**KIRKLEES METROPOLITAN COUNCIL
INVESTMENT & REGENERATION SERVICE**

Reference No:	2022/62/93557/E
Site Address:	82, Wakefield Road, Clayton West, Huddersfield, HD8 9NN
Description:	Erection of raised deck
Recommending Officer:	Jennifer Booth

OFFICER REPORT

Client J Field & L Brearley			
Project External Deck to 82 Wakefield Road Clayton West			
Drawing As Proposed General Arrangement			
Project no.	MOA 2119	Scale 1:50	Size A1
Drawing no.	[10] 06	Revision -	Status FA

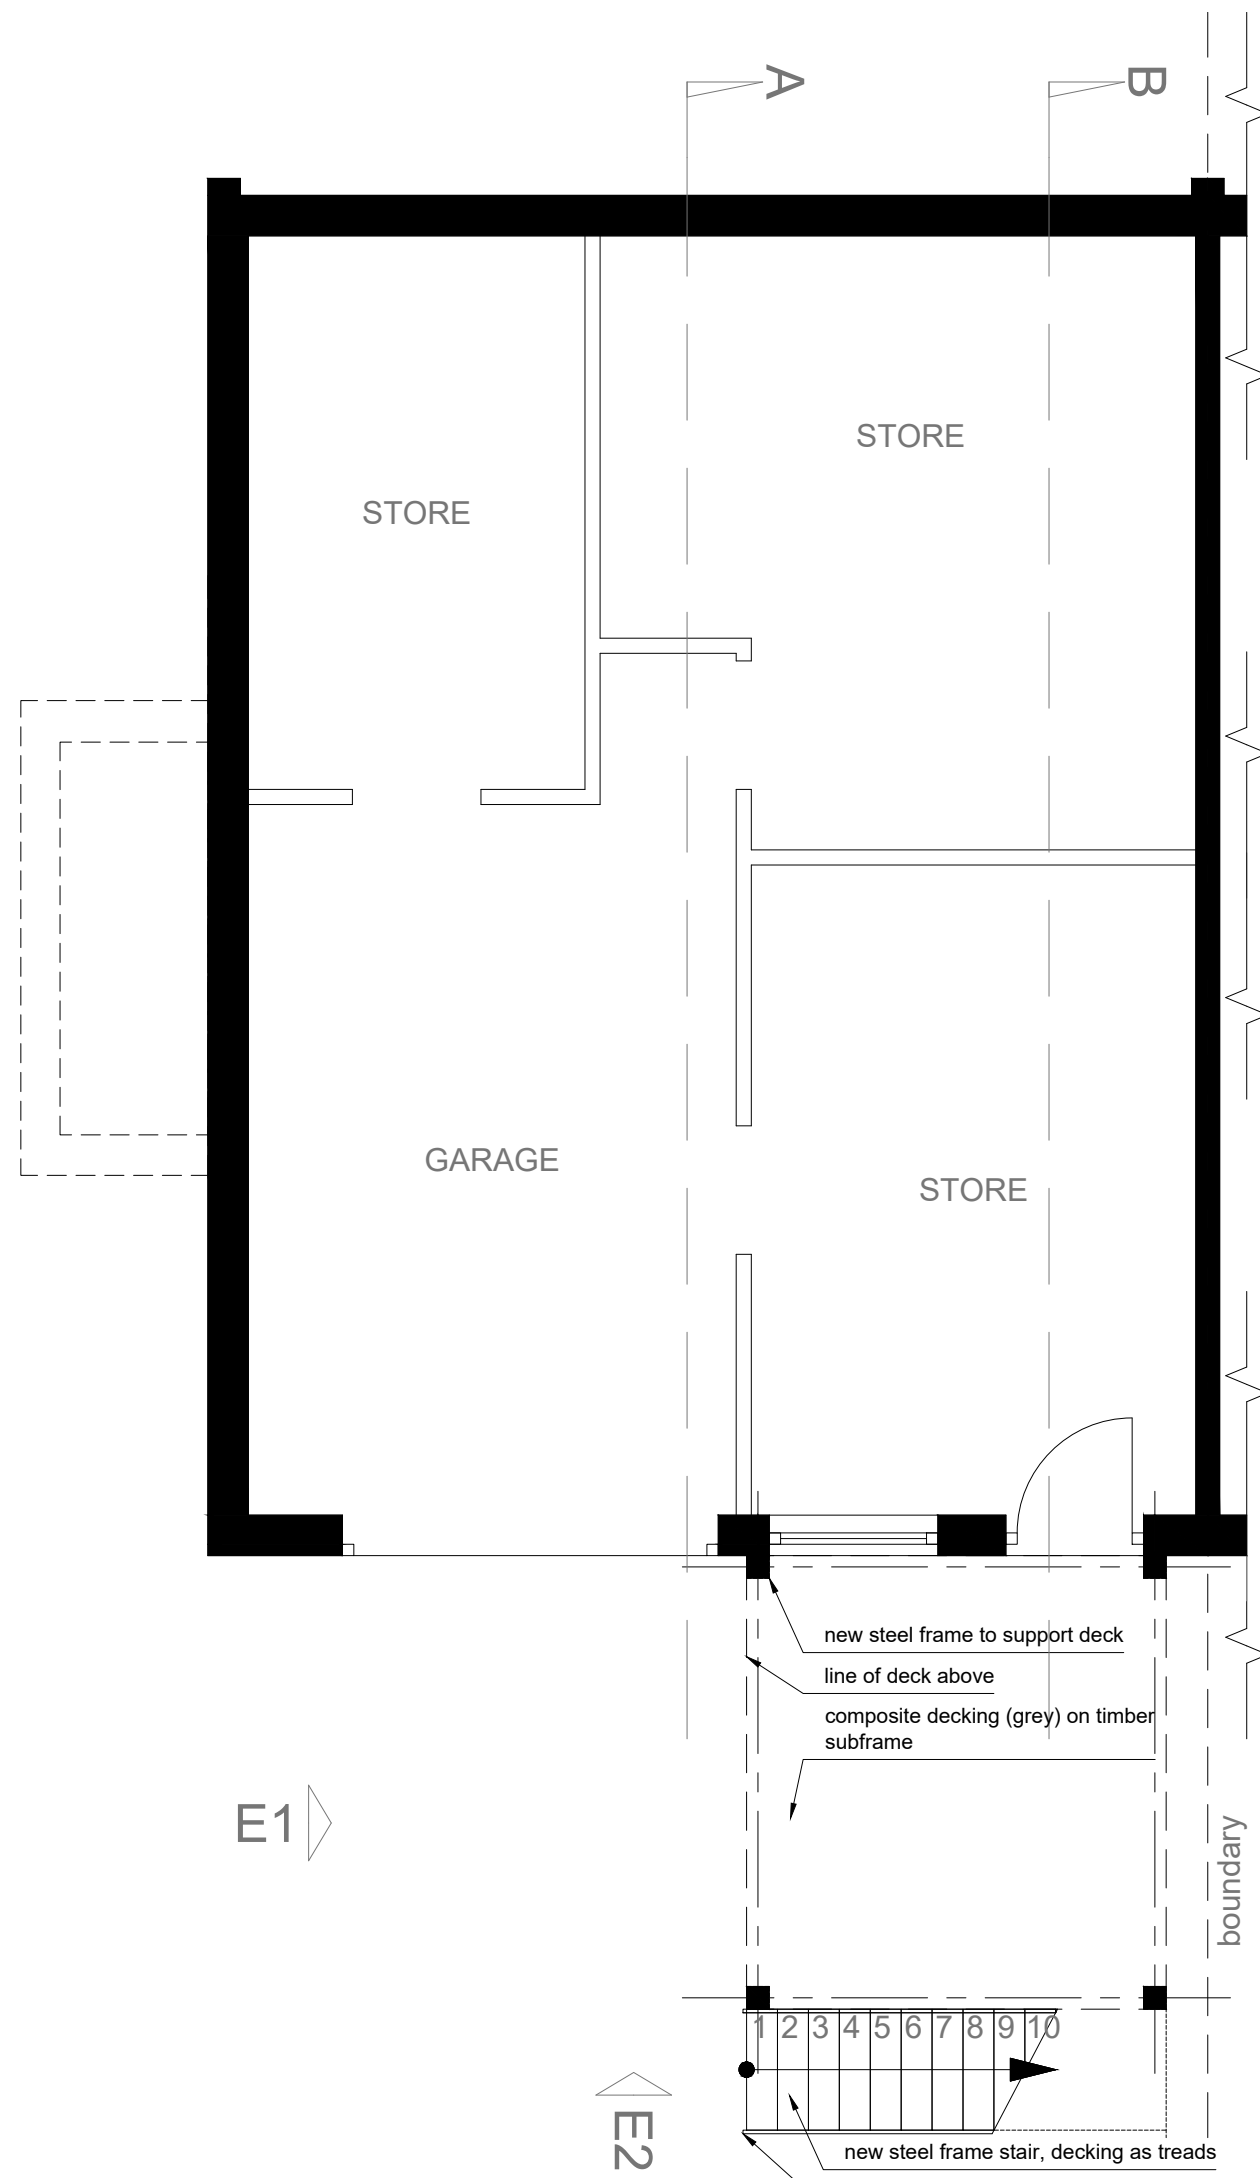
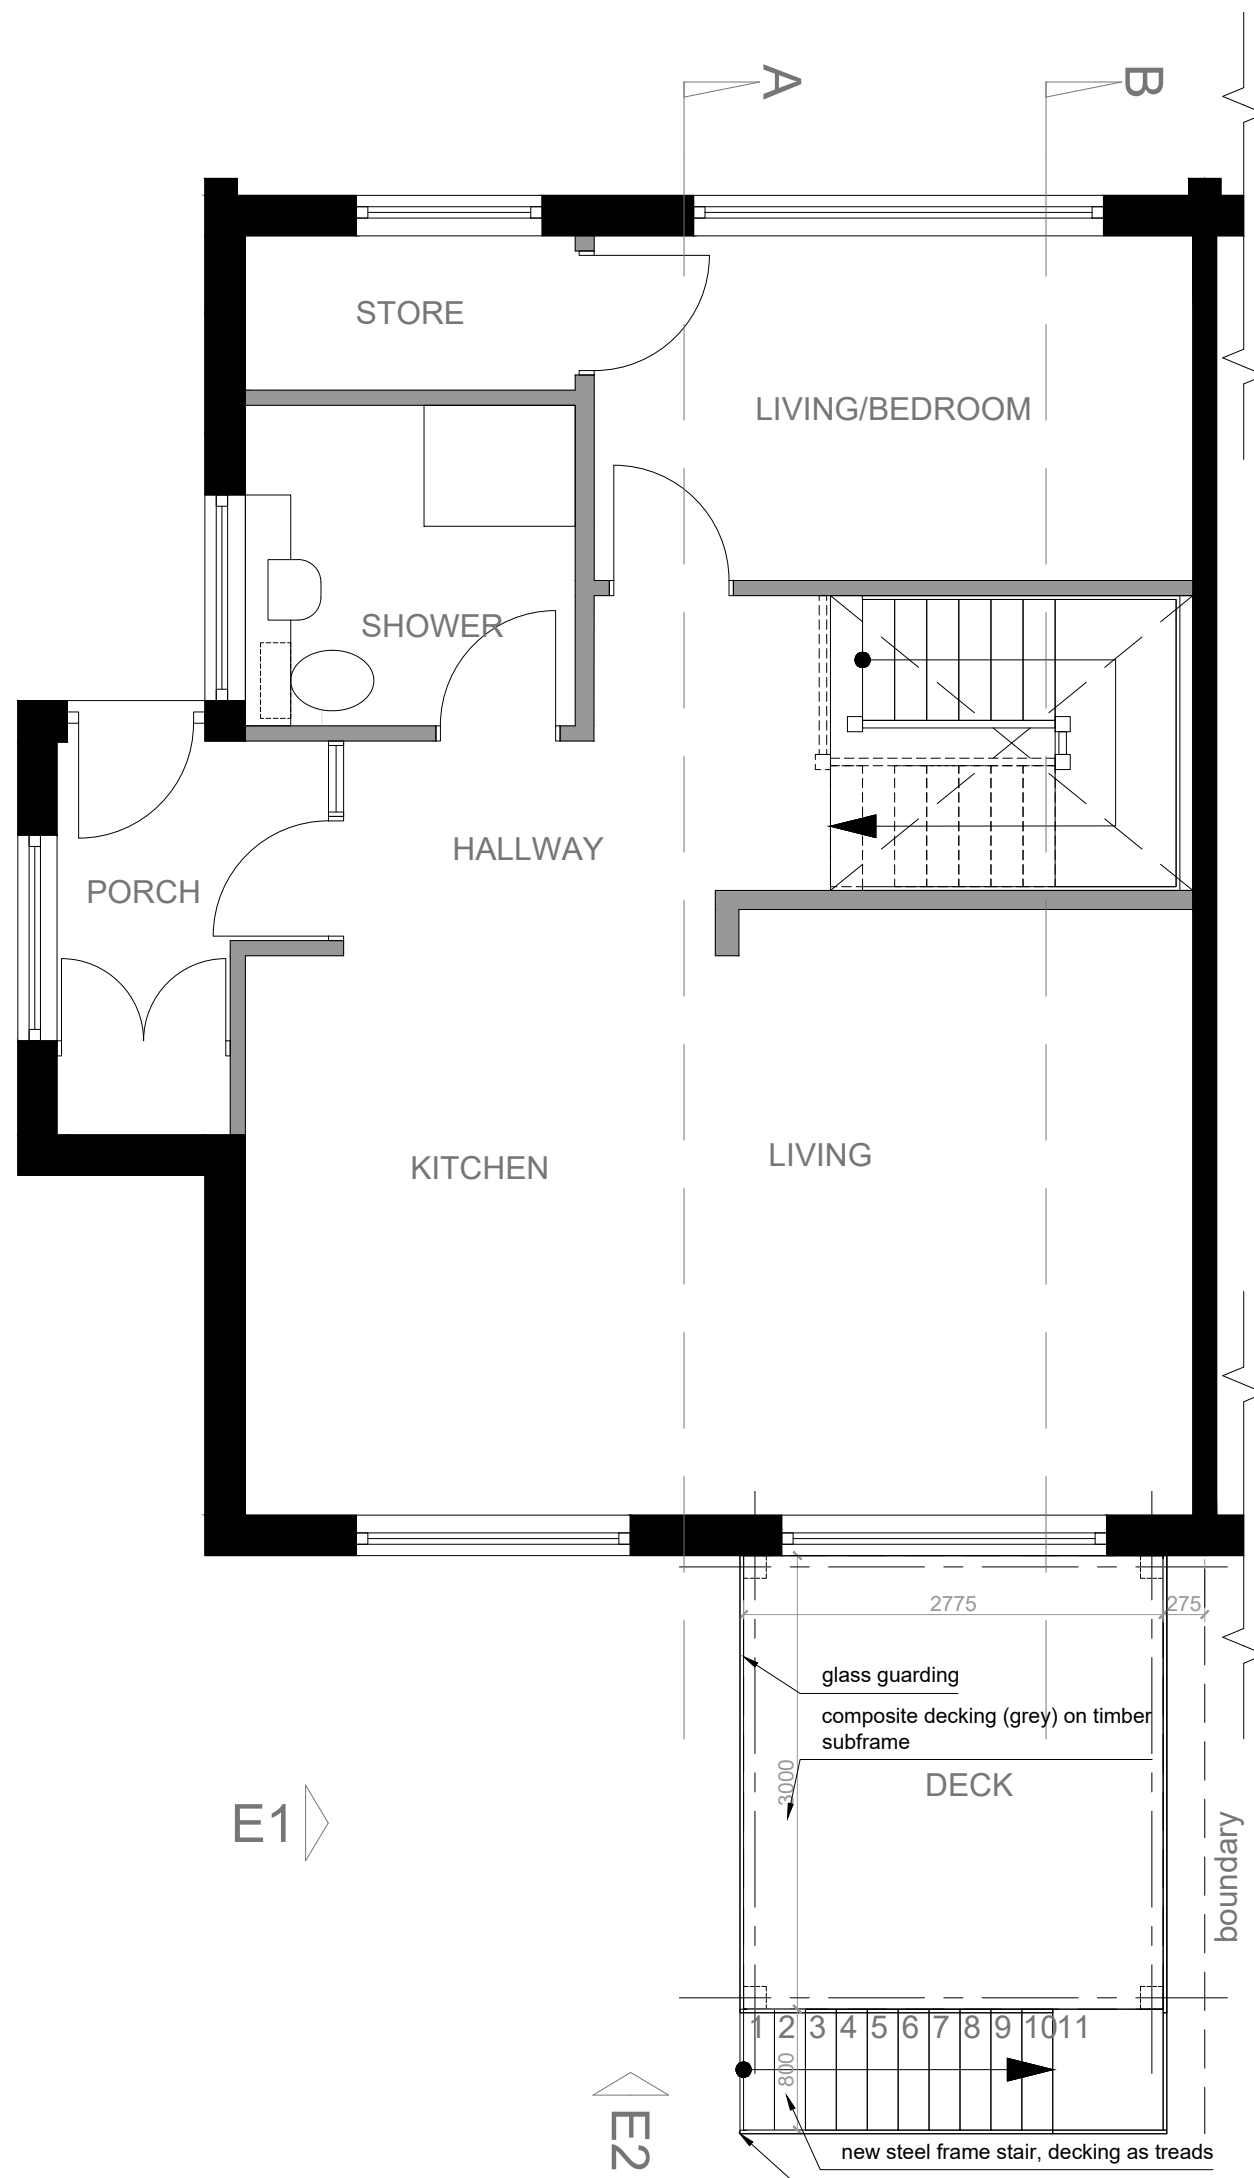
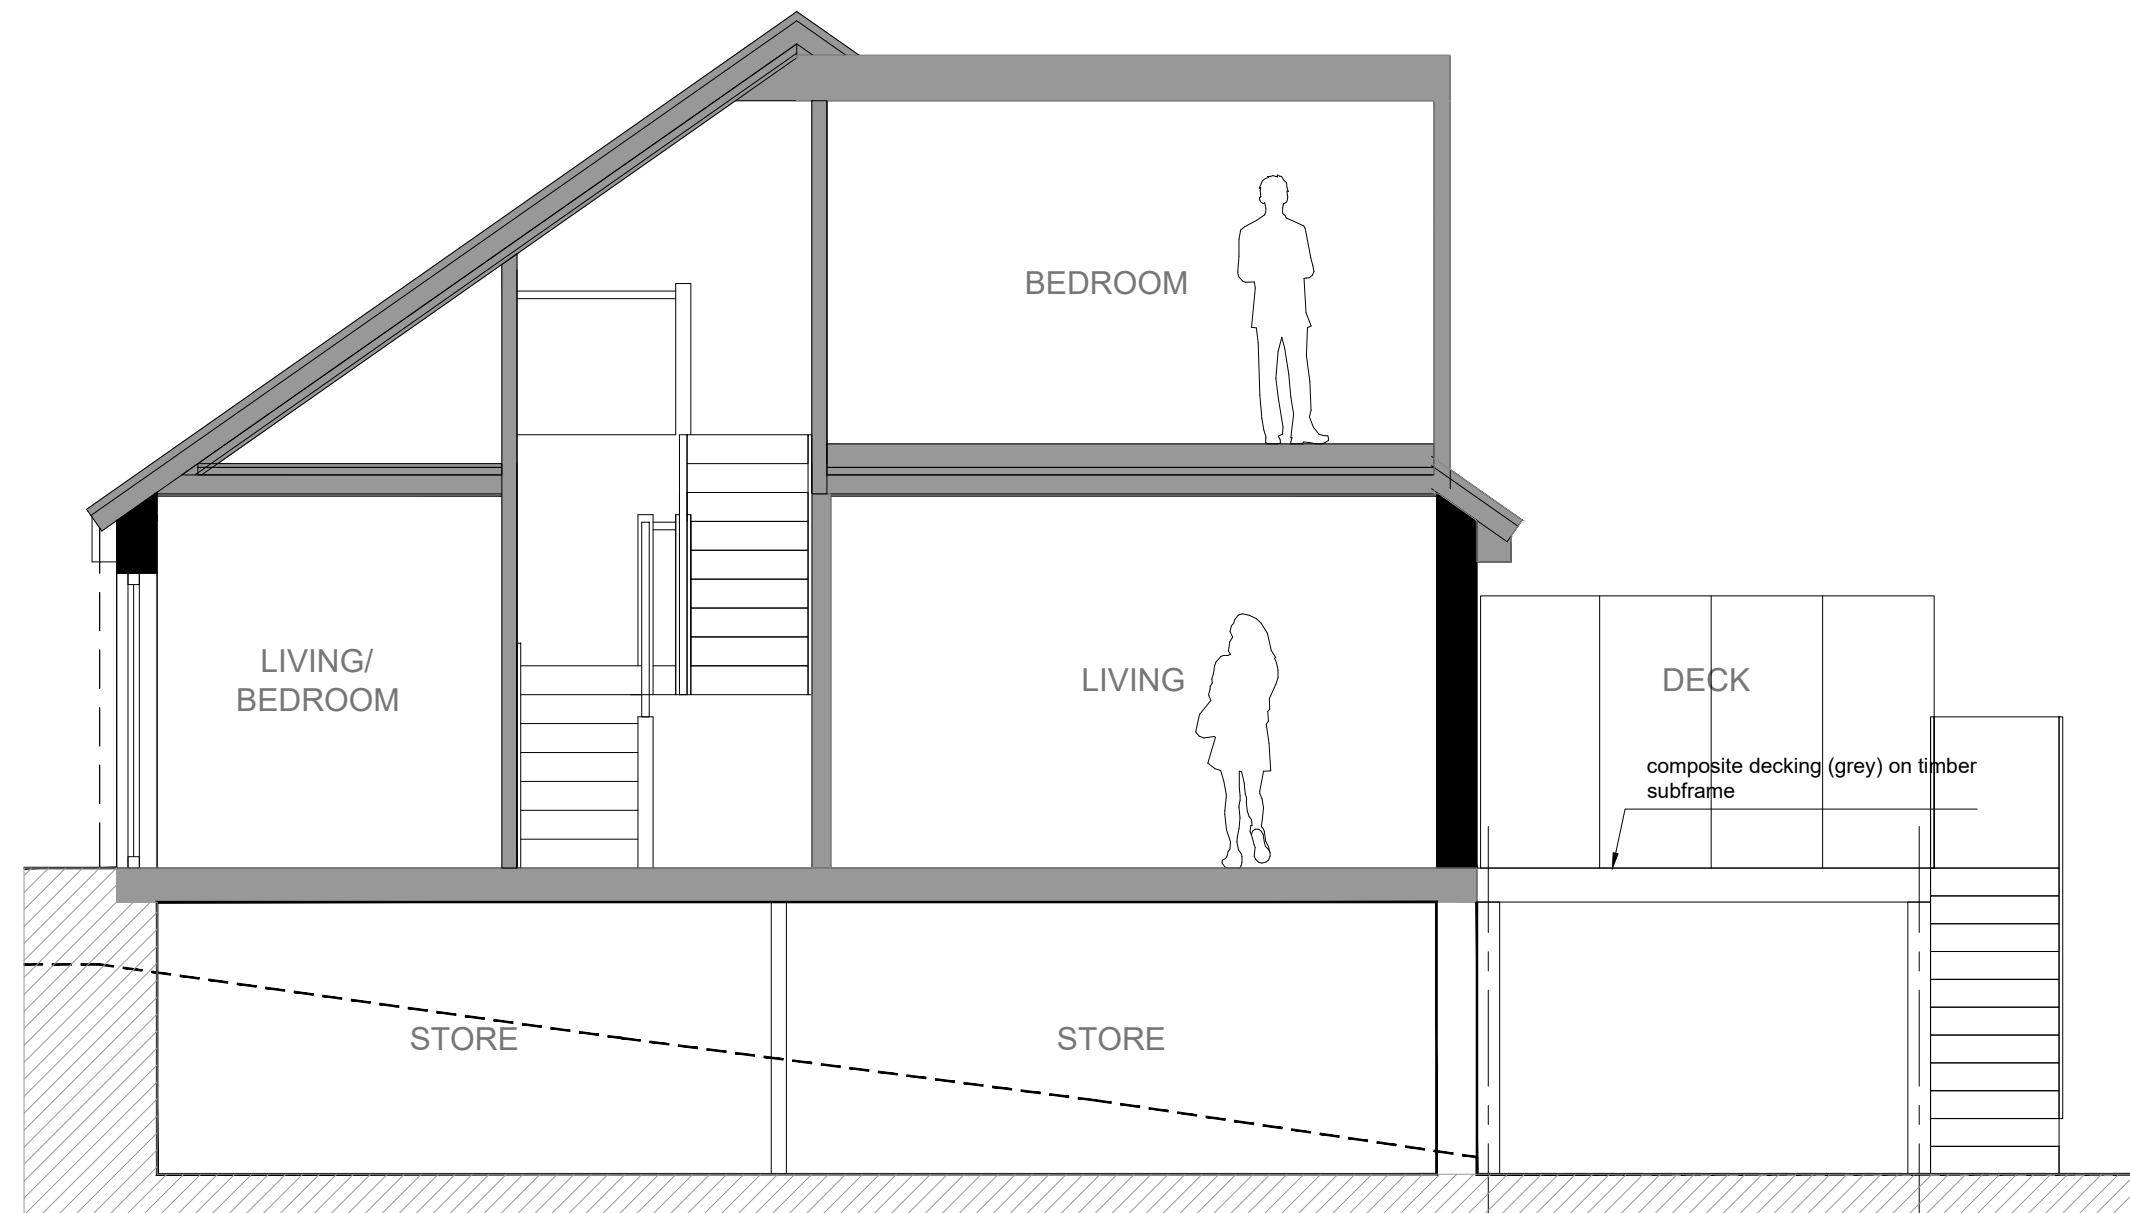
The platform of the raised decking would be 1.8m above the ground level with a projection of 3m, a width of 2.8m and an additional 0.9m for the stairs. The balcony would be enclosed with a 1.8m high glazed screen.

The balcony will be constructed using steel supports and beams, with a balcony floor structure, staircase, glass balustrade and obscurely glazed privacy screen along the boundary with the adjoining house. Although these construction materials do not match the existing dwelling, it is considered that they are acceptable, given that the materials will allow the structure to have a lightweight and unobtrusive appearance. In addition, these materials are common for this type of proposal, with the privacy screens welcomed from a residential amenity perspective.

The balcony would be constructed along the shared boundary with the adjoining property. To prevent overlooking, screening has been included. Given the materials proposed that will allow light to penetrate through, the limited projection, the screening would not result in any significant overbearing or overshadowing. The height and positioning of the screening proposed will prevent the potential for a loss of privacy in any of the rooms to the rear as a consequence of looking back towards the rear elevation of the neighbouring dwelling from the deck. A condition regarding the screening is imposed to ensure it is retained at a sufficient level in the position shown in perpetuity.

3. The privacy screen shown along the south western side of the deck/balcony, hereby approved, shall be maintained at 1.8 metres and shall be obscurely glazed to a minimum privacy level 4 or equivalent and shall thereafter be retained.
